OFFICIAL NOTIFICATION OF DECISION

Project# PR-2020-004017
Application#
SI-2020-01236 EPC SITE PLAN FINAL SIGN-OFF

All or a portion of TRACTS 2-A and 2-B, VAN BUREN LANDS OF BOARD OF EDUCATION, zoned NR-SU located at 800 LOUISIANA BLVD SE between KATHRYN AVE SE and LOUSIANA BLVD SE, containing approximately 2 acre(s). (L-18 & L-19)

- 2. The request is to construct a new police sub-station in two phases on the site, with Phase 1 including new construction of an 8,100 square foot building and the expansion of the eastern parking lot, and Phase 2 including the demolition of the existing police substation and the new construction of a 14,000 square foot building on the Site.
- 3. The proper notice was given as required by the IDO in Table 6-1-1.
- 4. Per the City Engineer paper easements are required prior to Certificate of Occupancy for a required sidewalk easement on Louisiana as well for Kathryn to incorporate the required 4-foot wide sidewalk.
- 5. <u>Pursuant to 6-6(H)(3) Review and Decision Criteria An application for a Site Plan EPC</u> shall be approved if it meets all of the following criteria:
 - a. 6-6(H)(3)(a) The Site Plan is consistent with the ABC Comp Plan as amended.

C1 SITE PLAN - EPC FULL BUILD OUT

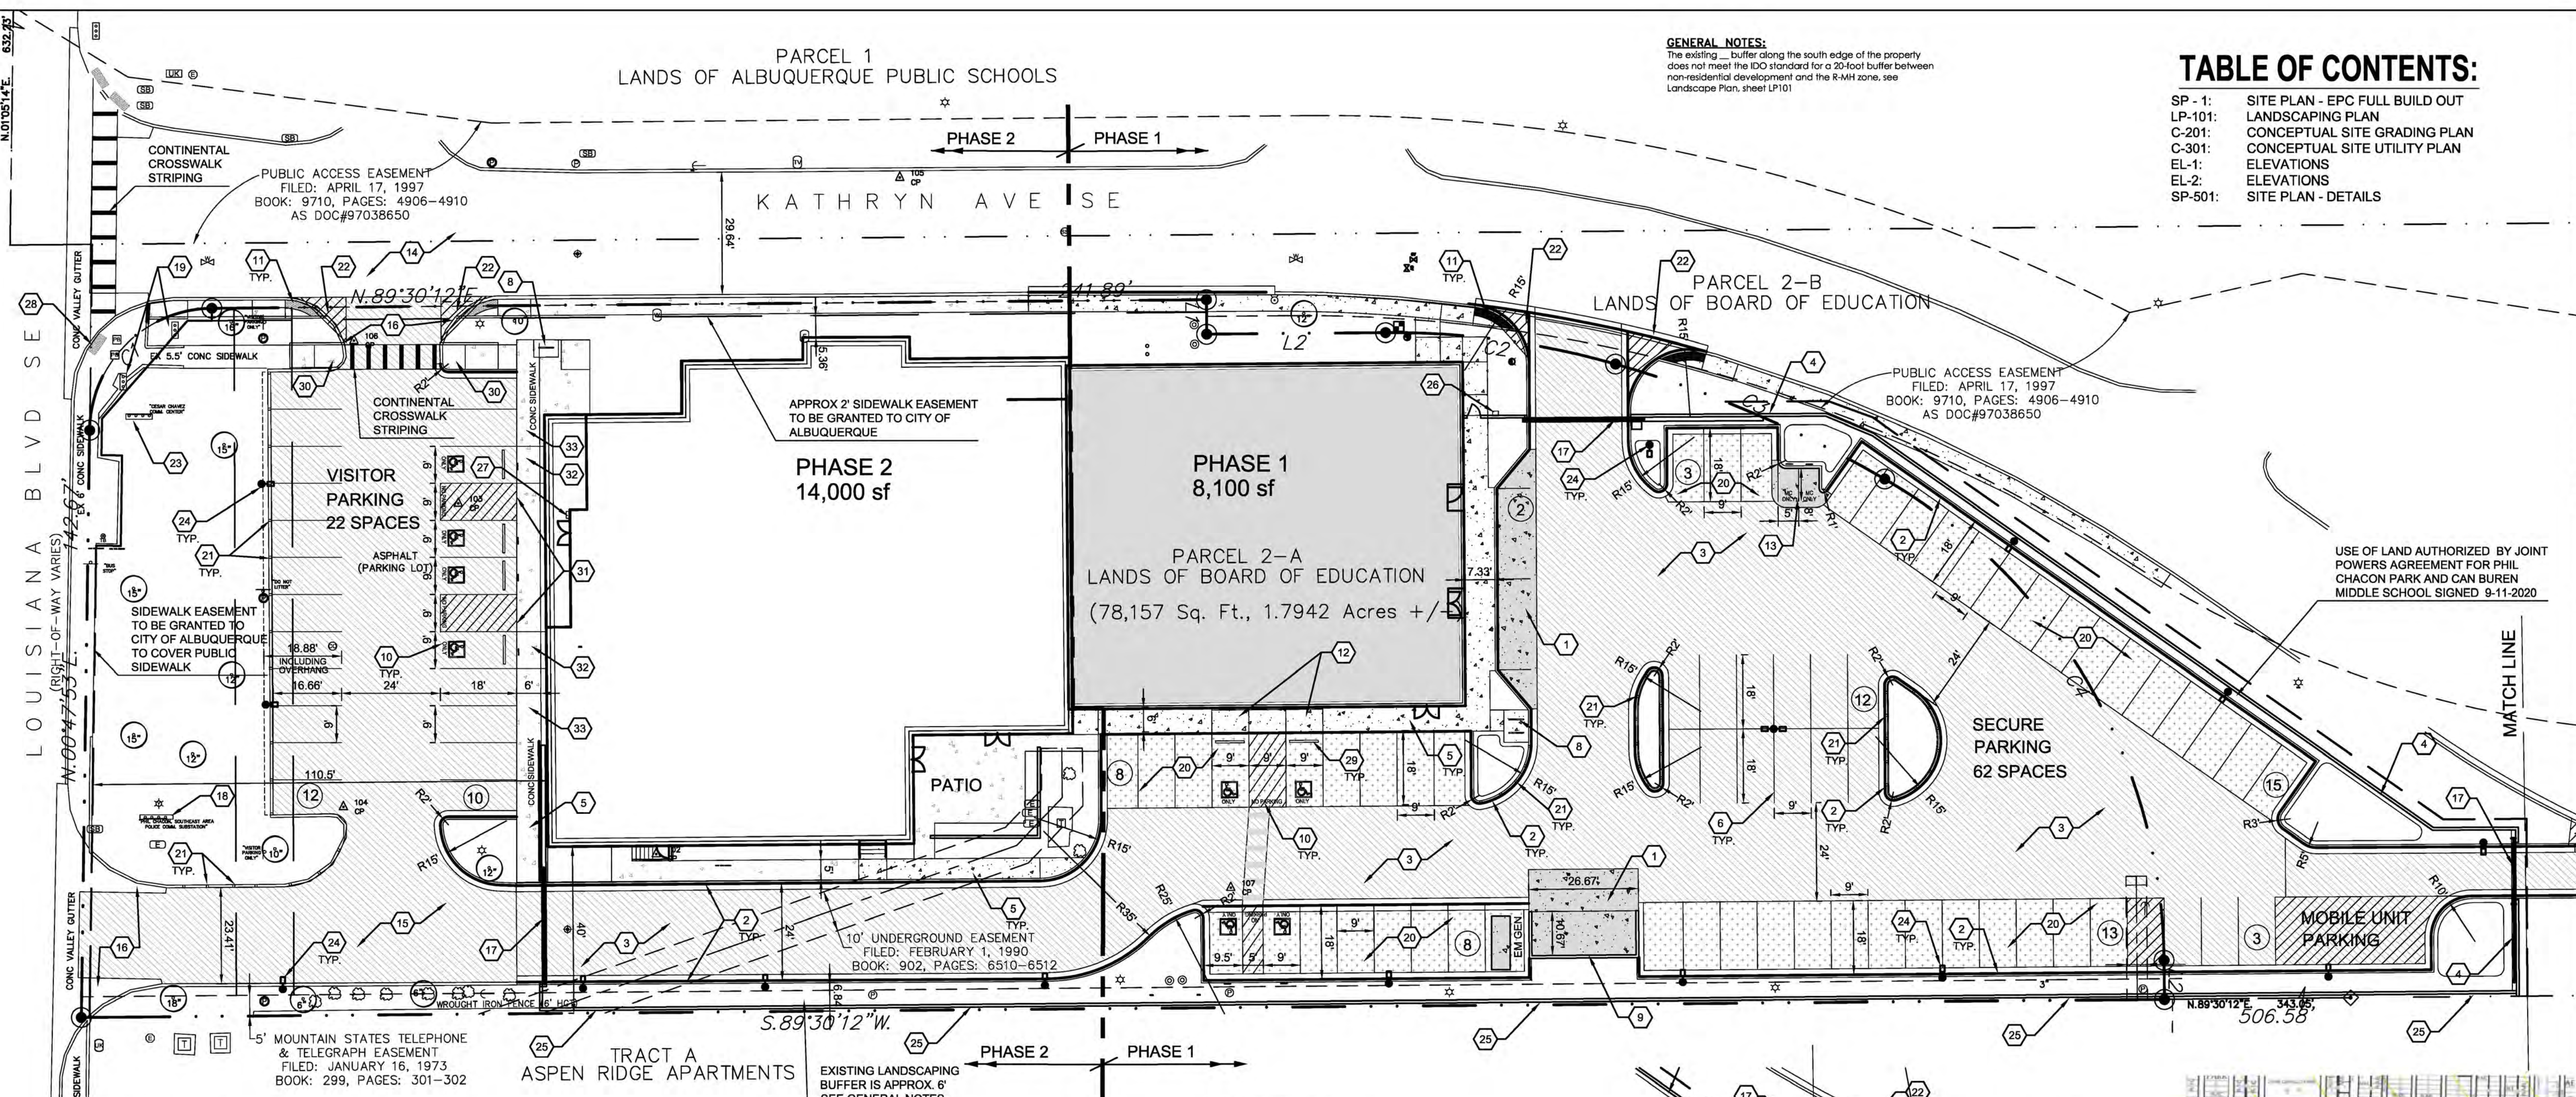
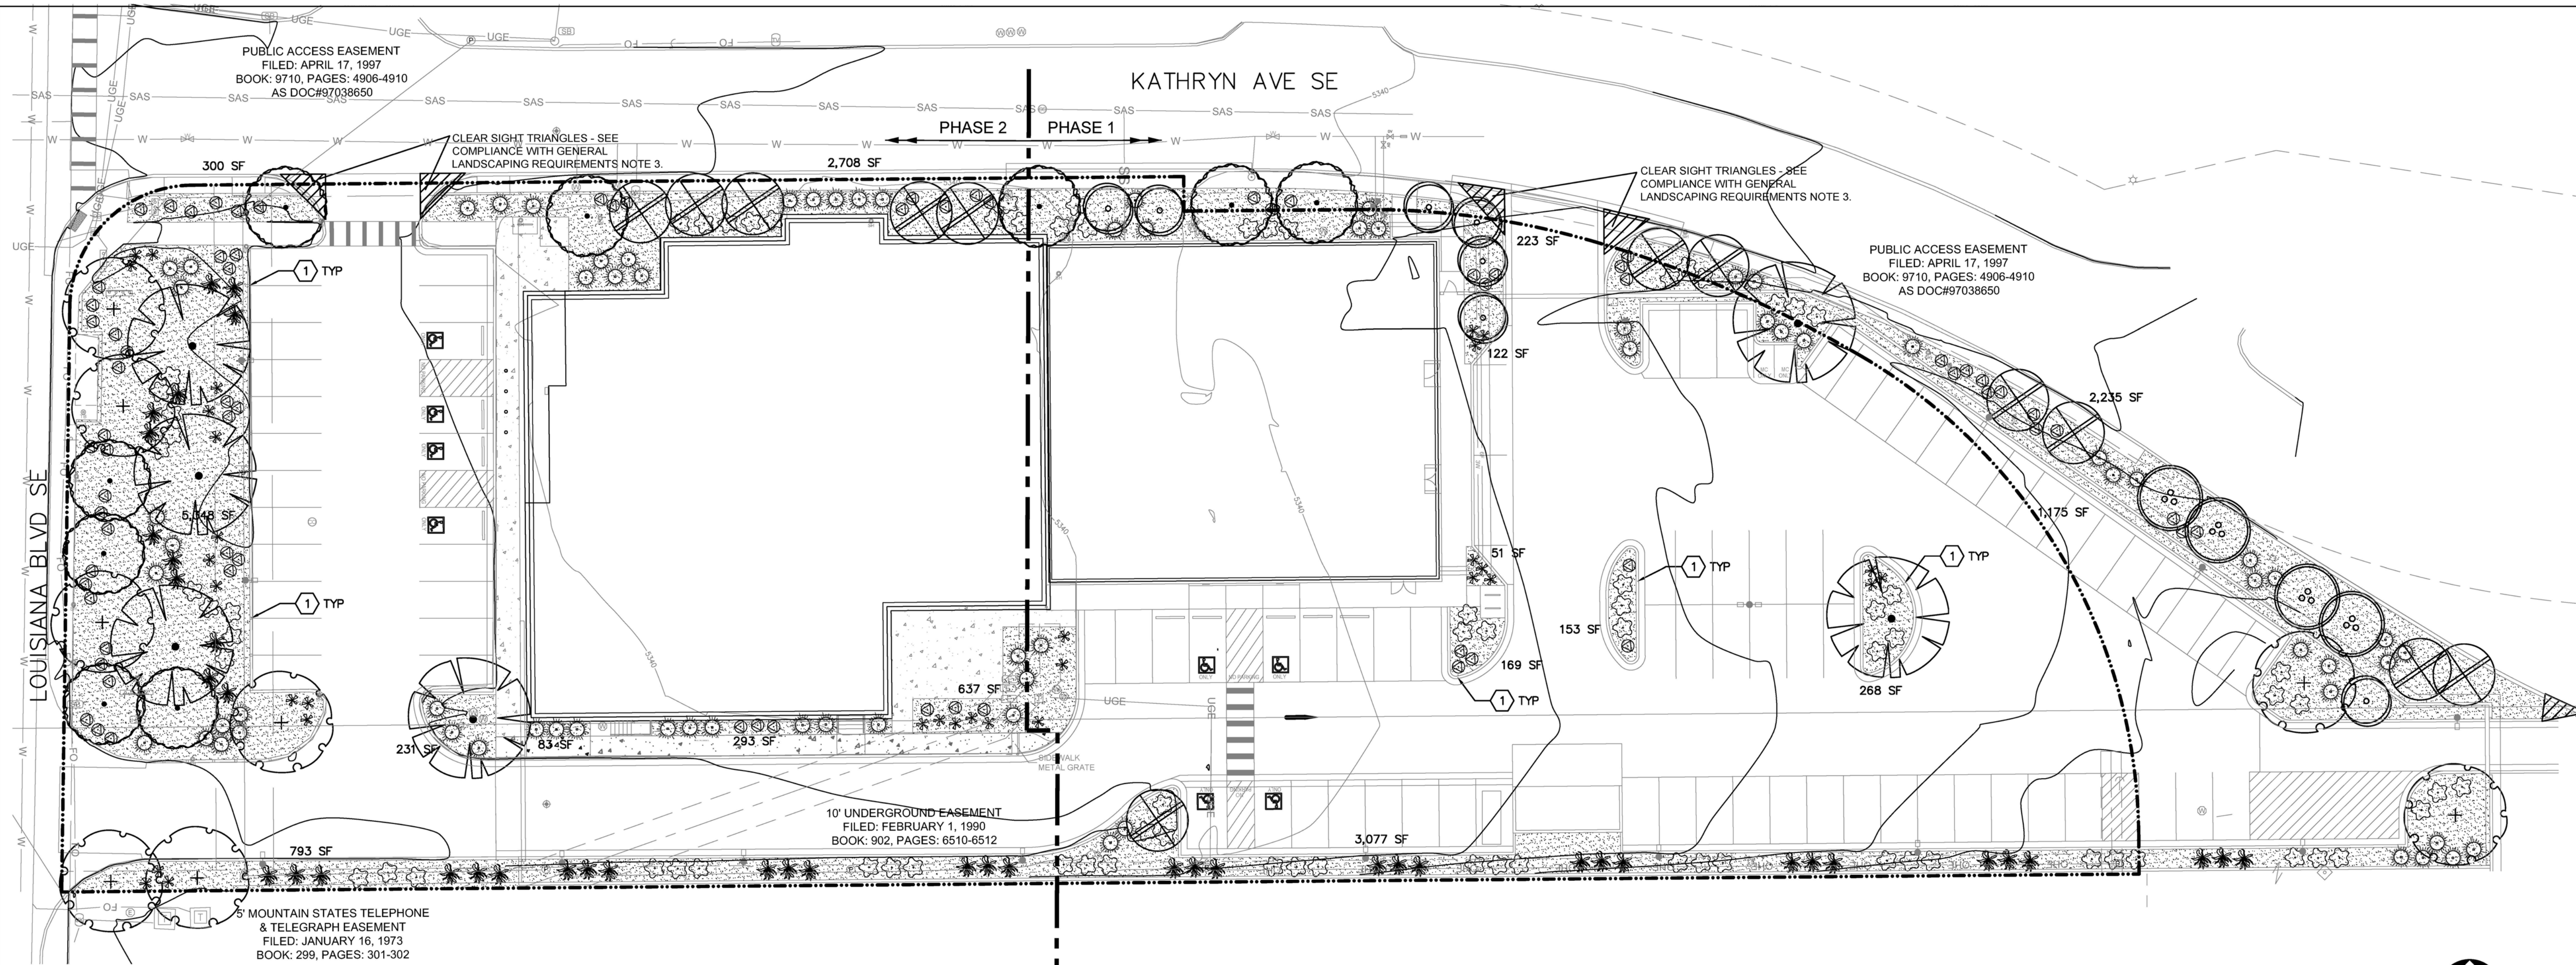
- 1. Final sign-off is delegated to Transportation to clarify whether the 16-foot parking spaces are compact or standard with overhang, to show dimensions of van-accessible isles and motorcycle spaces, put in truncated domes for the southeast corner of Kathryn and Louisiana, a knox box called out for each of the vehicular gate locations, clarification on the curb ramps for keyed notes 11 and 12 and have the correct curb ramp details called out, and clarify whether or not there is curb along the east side of the visitors parking area.
- 2. Final sign-off is delegated to Planning for final sign-off.
- 3. The applicant will obtain final sign off from Transportation and Planning by January 18, 2021 or the case may be scheduled for the next DRB hearing and could be denied per the DRB Rules of Procedure.

A1 LANDSCAPE PLAN

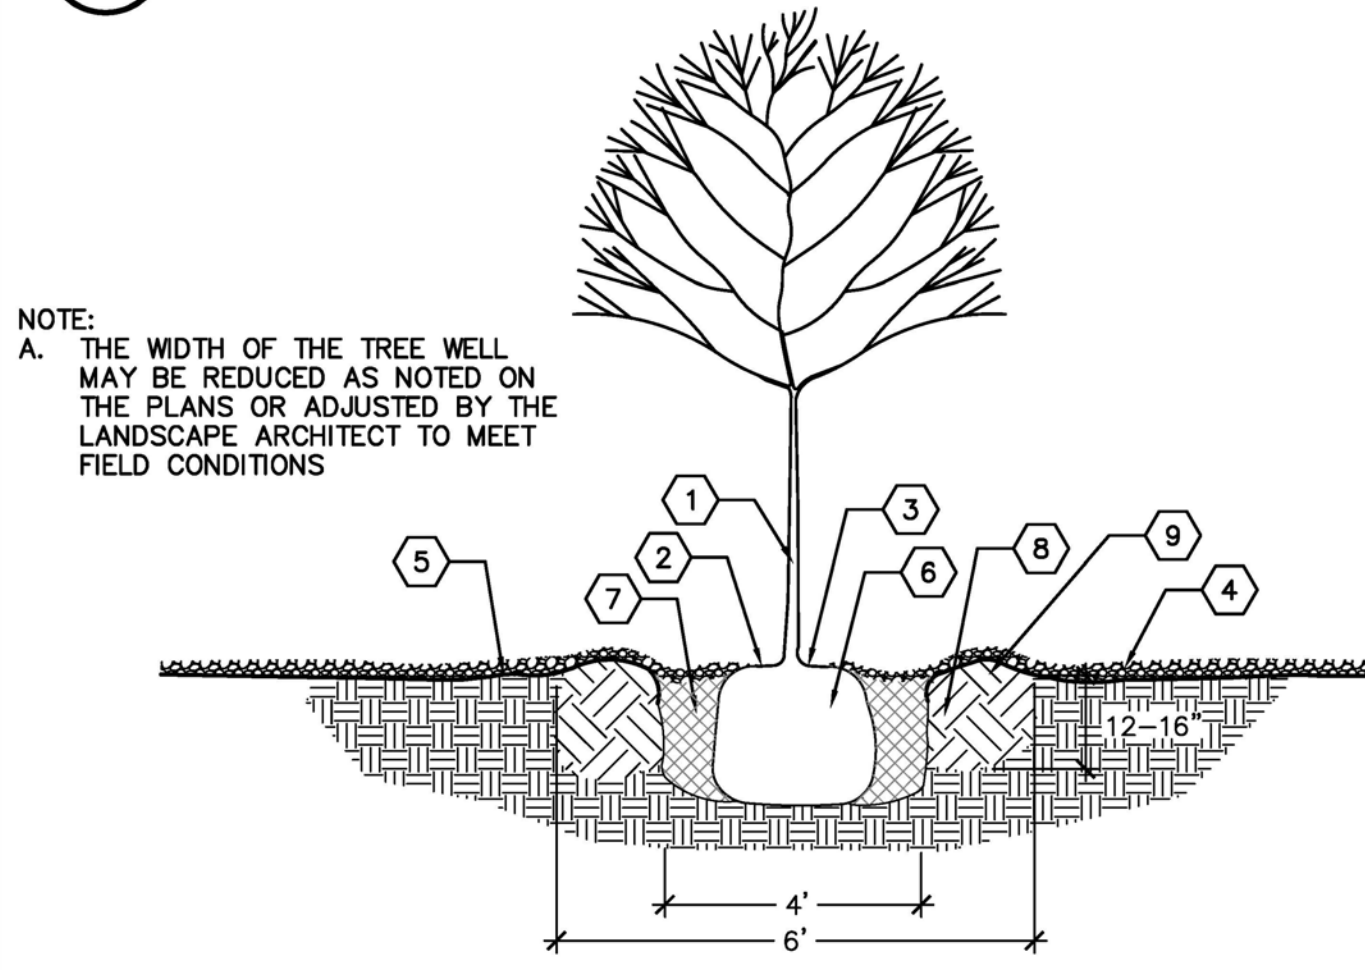
The features and improvements depicted on the Site Plan meet the IDO requirements including parking and landscaping with the exception of the landscape buffer along the southern boundary of the Site, which requires a 20-foot buffer per 5-6(E)(3) of the IDO, while the Site Plan depicts a 7-foot wide buffer. In the staff report for the EPC Site Plan application, EPC staff stated that the applicant adequately explained that there was concern about the landscaped areas located within the utility easements on the southern portion of the Site. The landscaping plan shows 9,982 square feet of landscaping required and 17,763 square feet is provided. Phase 1 of the project requires 35 parking spaces and will be providing 86 parking spaces; Phase 2 of the project requires 45 parking spaces and will be providing 86 parking
